## **SCOPING OPINION:**

# **Proposed Able Marine Energy Park Material Change 3**

**Case Reference: TR0310001**

**26 February 2025**

Scale: 1:5,000	DA UN O	Drawn By: D Almeida	Checked By: R Crum	Approved By: P Stephenson
Originator: RC/PMS	21/05/2024	29/08/2024	29/08/2024	
Drawing No: AHP-030-00017				Revision: E

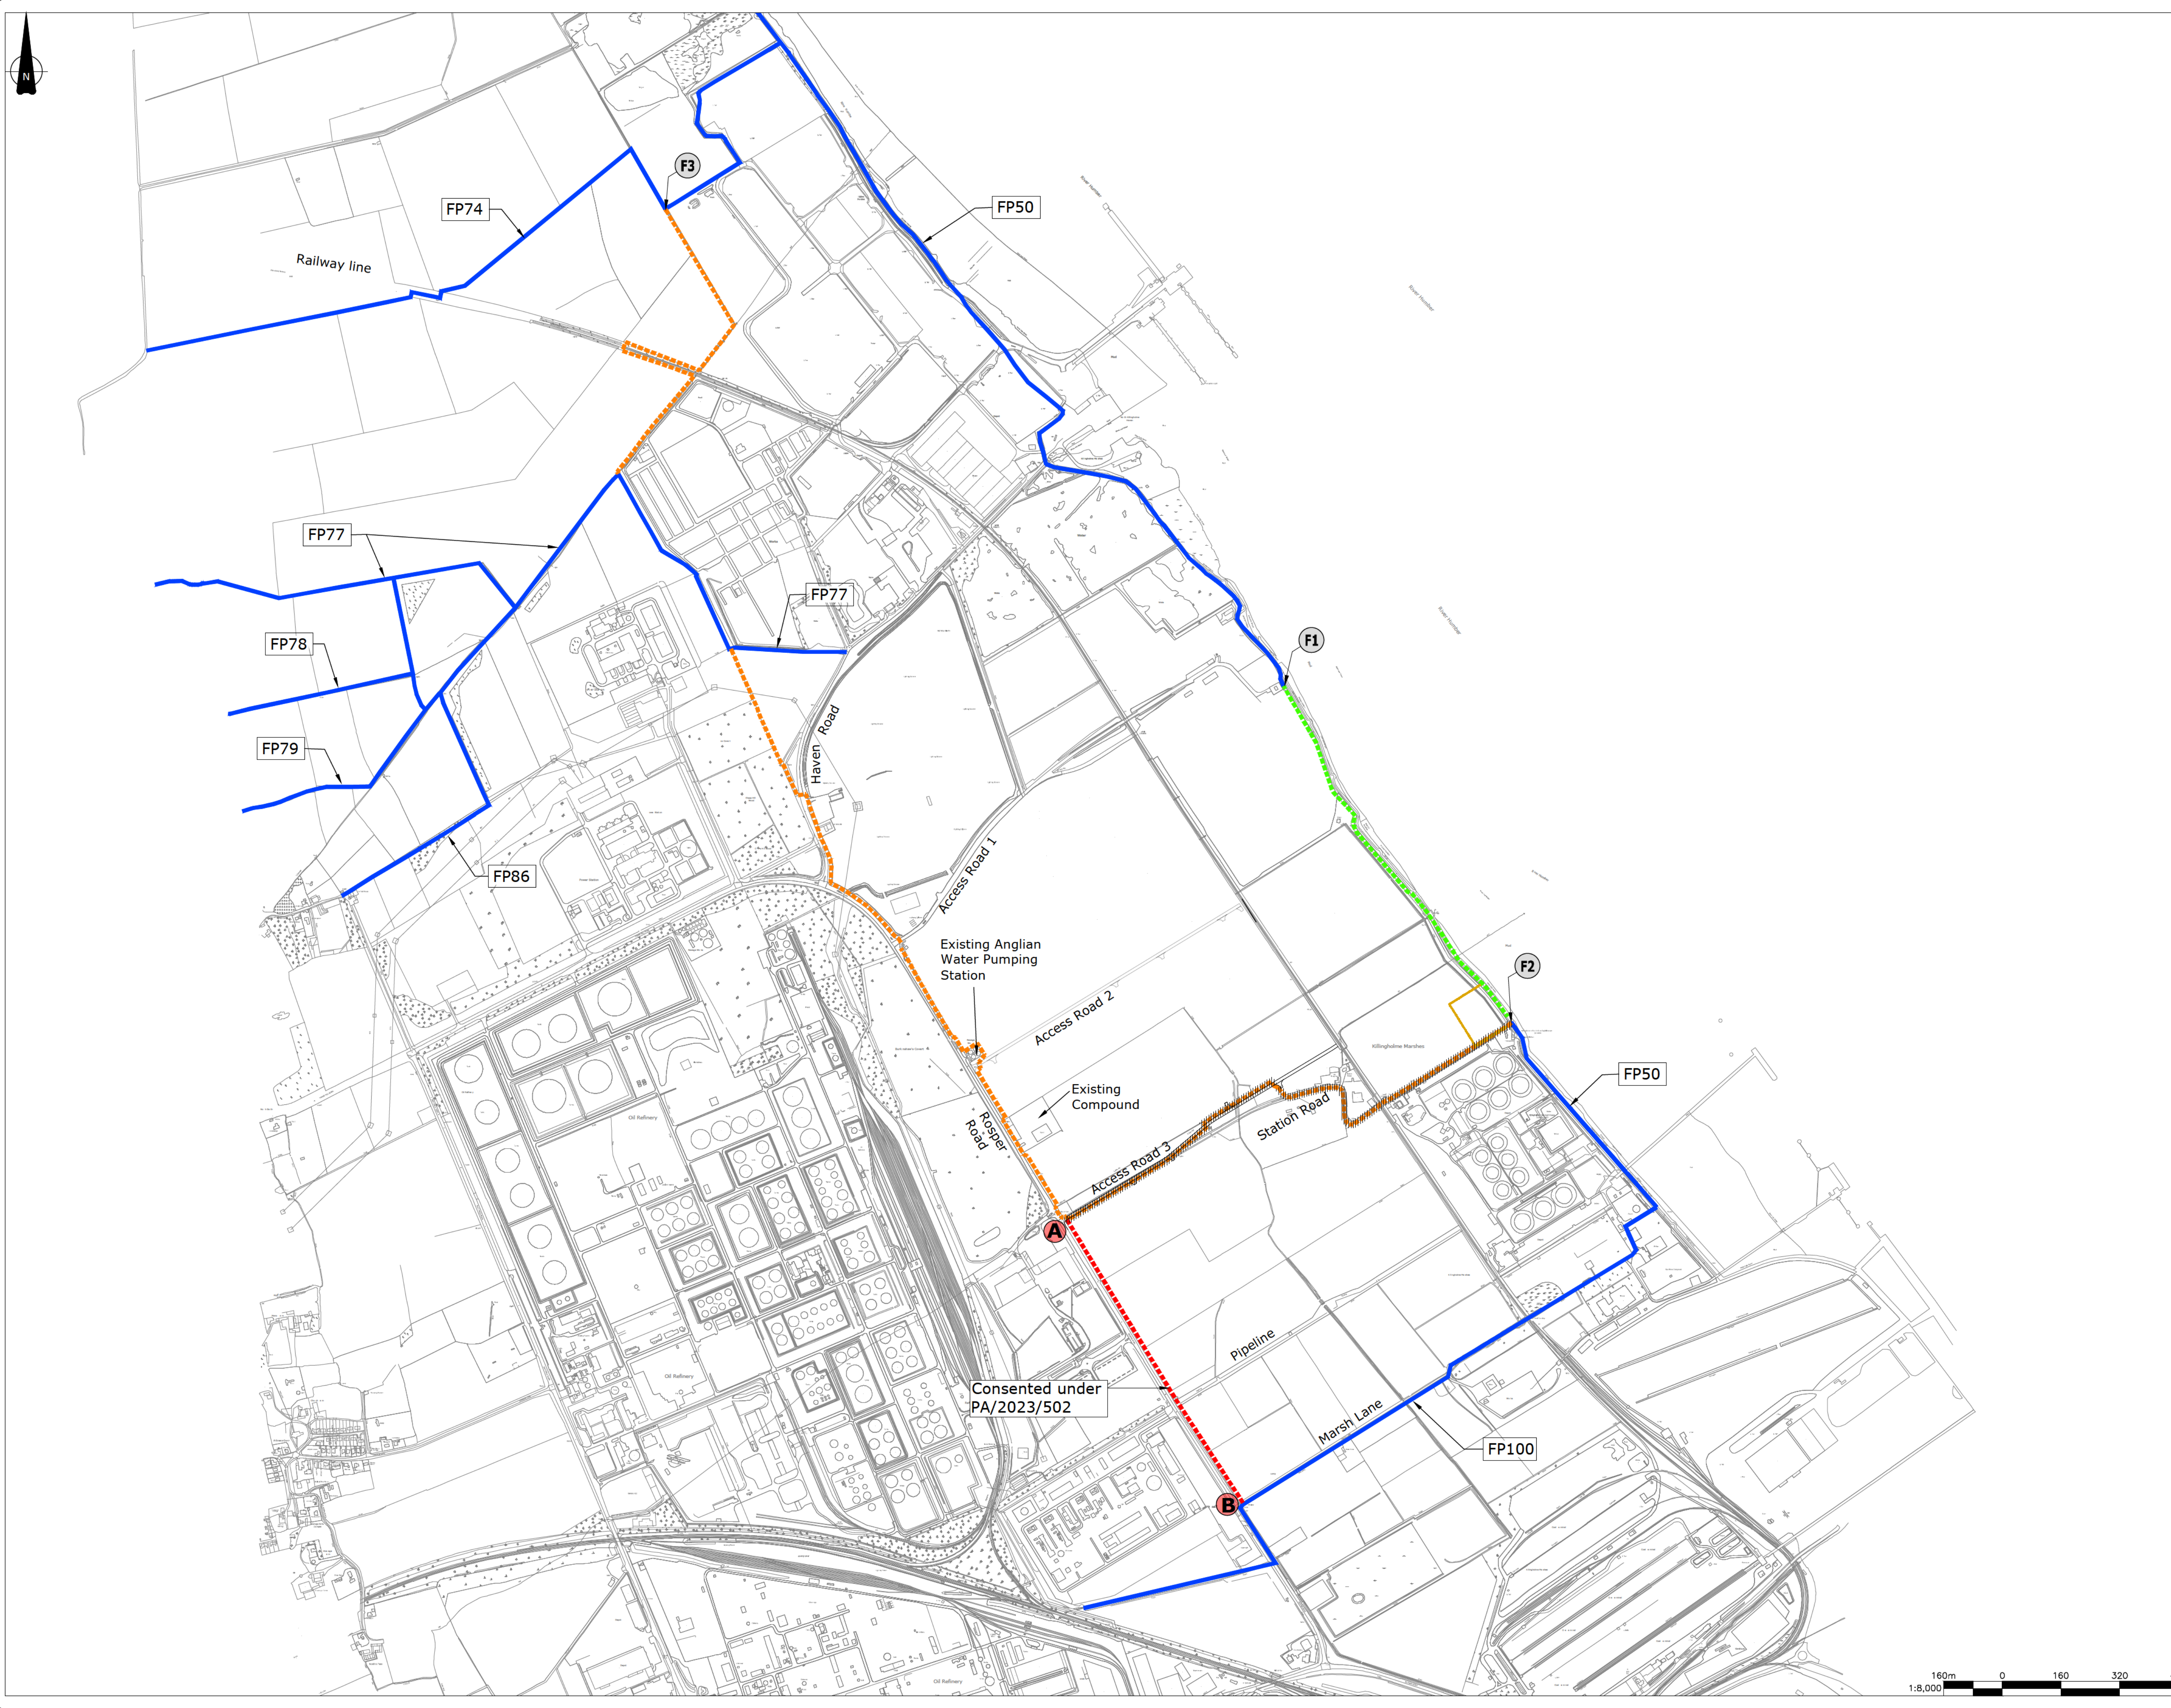
ID	Ref	Description	Inspectorate's comments
21.1	Paragraphs 2.2 and 2.9	Construction of the quay in stages 2 and 3	<p>Scoping Report paragraph 2.2 states that the construction of the quay will be completed in discreet stages. Whilst these are identified on Drawing AHP-030-00017, the stages of construction are not described. It also states that there would be no obligation to complete the whole of the quay within the specified timeframe.</p> <p>The Inspectorate considers that there is potential for the baseline to change over time and without estimated times for construction of the quay in stages 2 and 3, impacts may be unknown e.g. the intensity, timing and duration of dredging. It also brings into question the delivery of some of the mitigation measures, for example, those that are to be delivered following the completion of the quay including measures to protect sea defences as highlighted by the Environment Agency (EA).</p> <p>The ES should describe each phase of construction of the quay, explain what would initiate each phase to begin and over what timeframe it would be completed. Where there are multiple scenarios, the ES should describe the relevant worst-case scenario to the aspect being assessed and provide an assessment of likely significant effects in the relevant aspect chapters.</p>
